CA Determination Response Memo

New Horizon Real Estate Development
8375 + 8379 East Mercer

Below are Responses to the memo regarding Critical Area Determinations CA017-008 + CA017-009 dated 27 October 2017.

C3.0

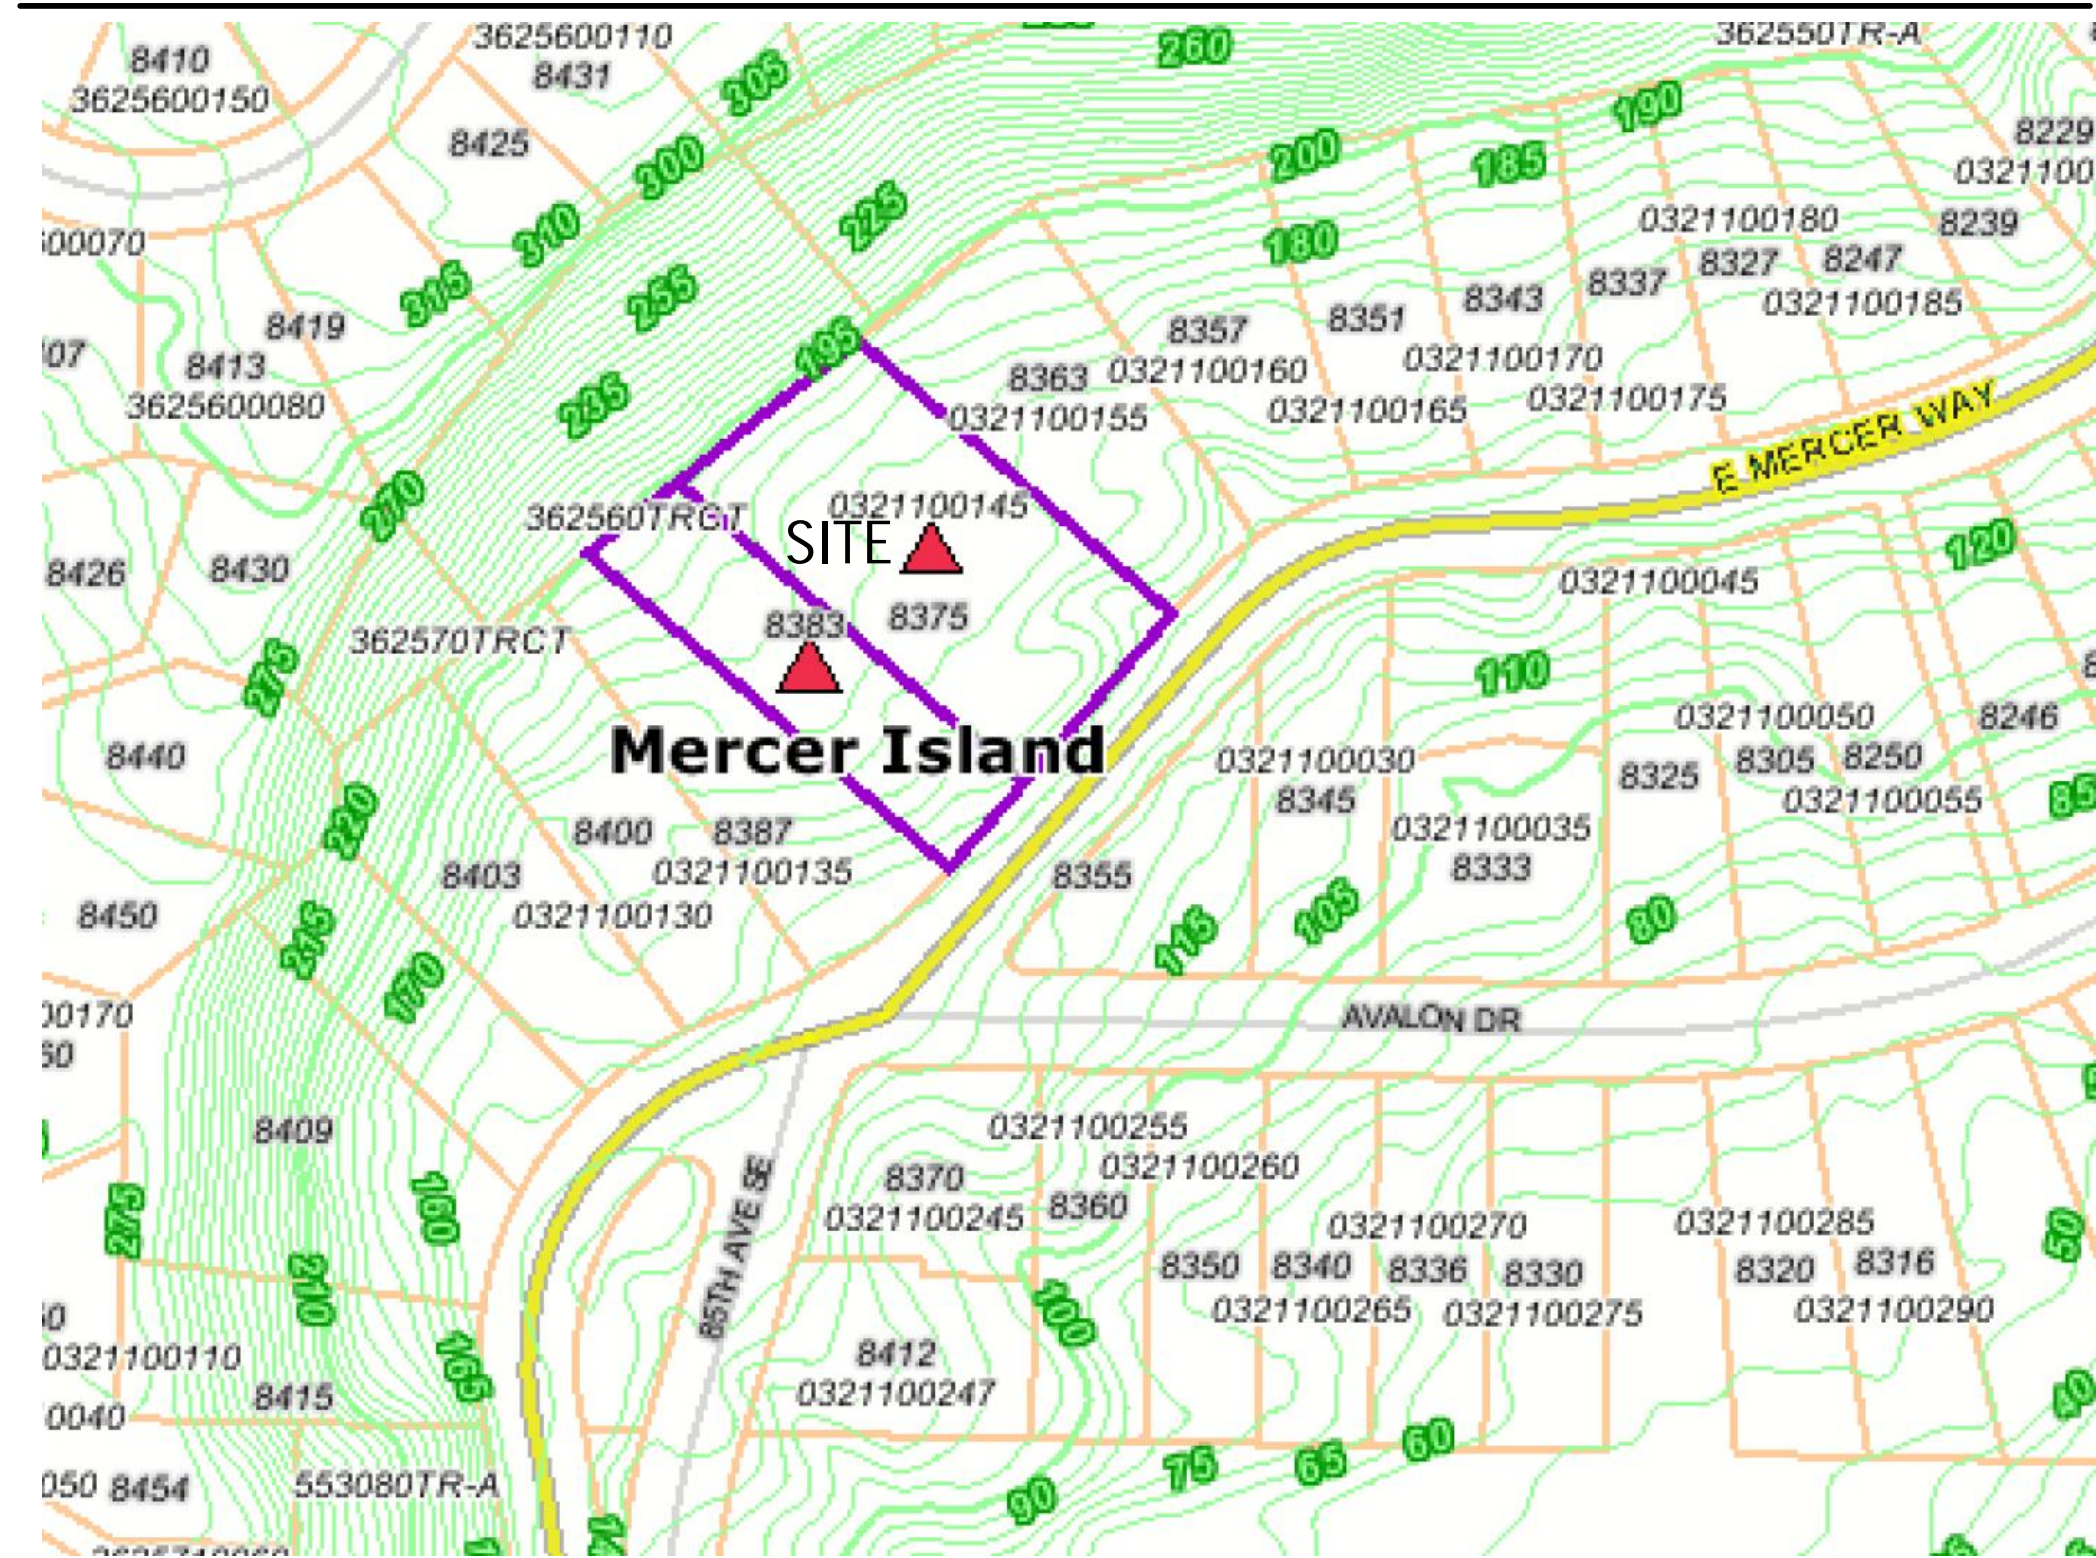
2. Please see included memo from Evergreen Aquatic responding to the memo from ESA.
3. In response to the letter from Roger Shantz;
 - 1) Any and all regrading will be confined to the subject properties per Mercer Island Municipal Code 19.09.060.G
 - 2) Every reasonable effort will be made to protect trees
 - 3) Duly noted. Property owners will be made aware of the desire to have a conversation regarding the stump.
 - 4) Please note that these trees are taken under consideration and are planned for protection as part of the erosion control plan (C1.0)
 - 5) Please see response from Evergreen Aquatic addressing changes to the wetland area
 - 6) Duly noted. Property owners will be made aware of the desire to have a conversation regarding the preservation of the cherry laurels.
